RE: Roukema Buchanan Residence  
LA-12869

I am writing concerning the height of backfill at the rear porch for the Roukema Buchanan residence at 857 Holly Springs Church Rd.

3. WALL SECTION 'C'
SCALE: 1"=1'-0"

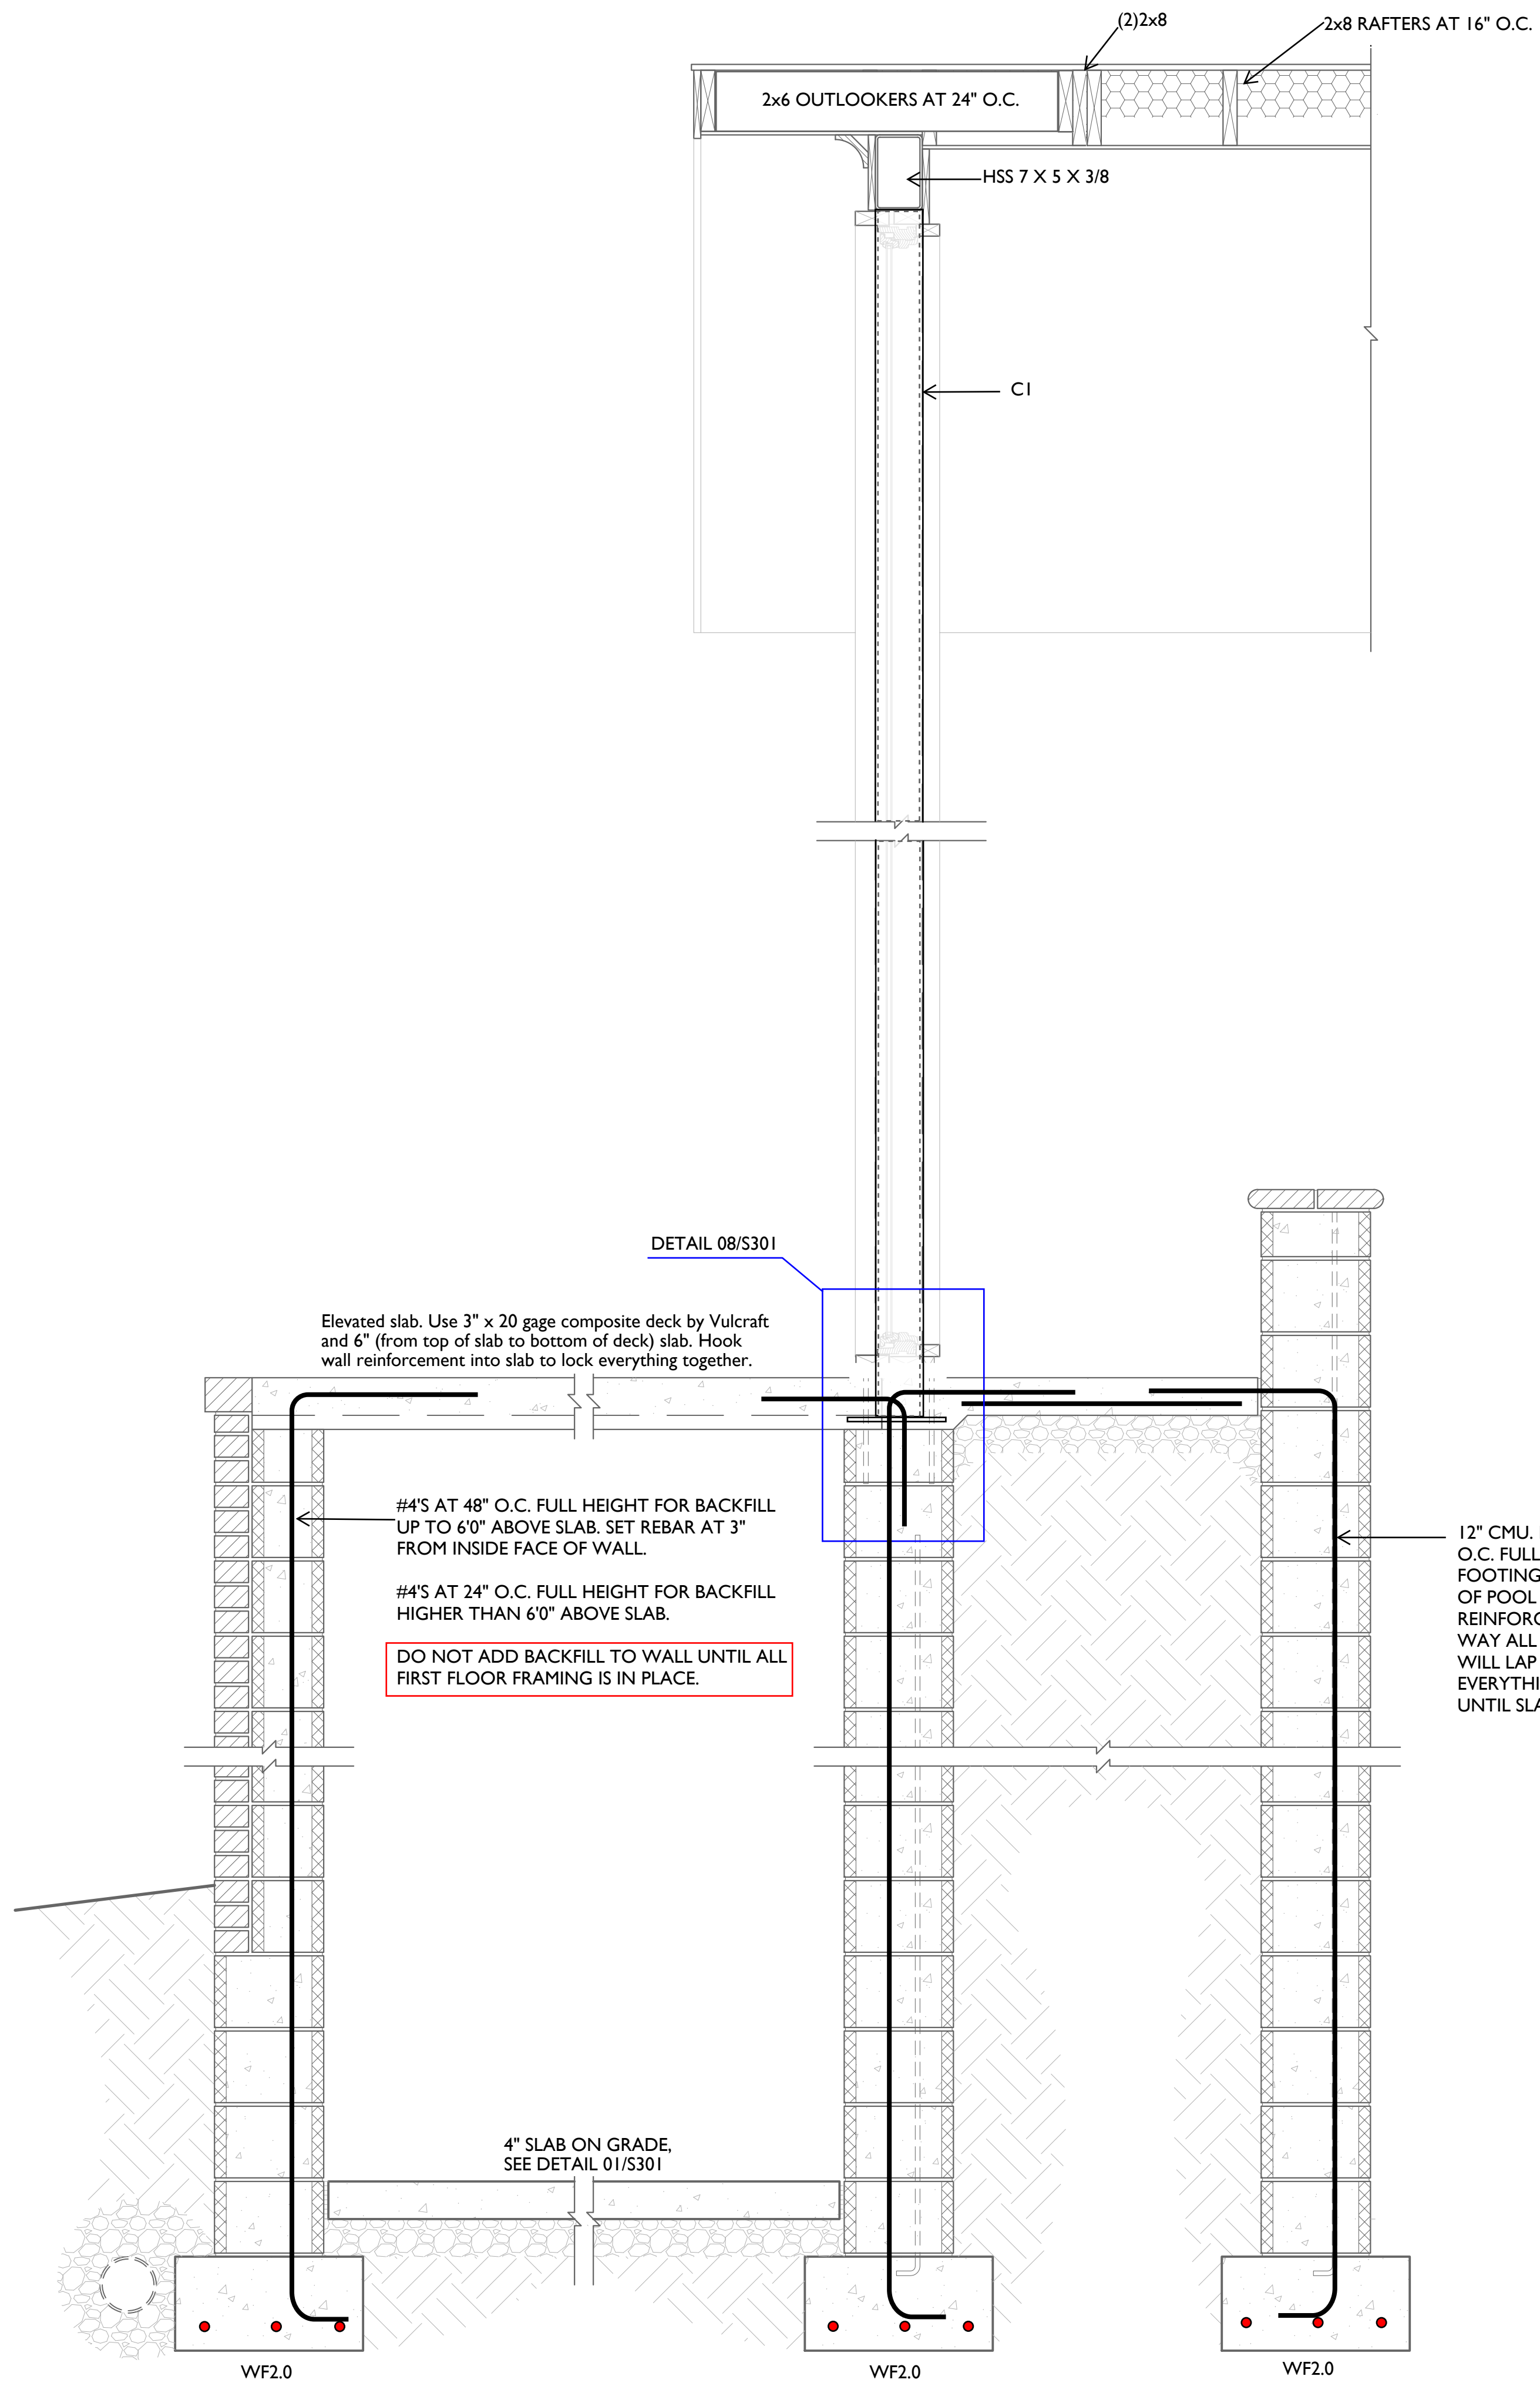
We designed the wall and slab for the height of backfill shown on the drawings.

Detail 3/S201 shows how the wall and slab are reinforced and tied together. It also calls out the #57 stone to use for backfill and specifies that the wall must be braced until the slab has cured.
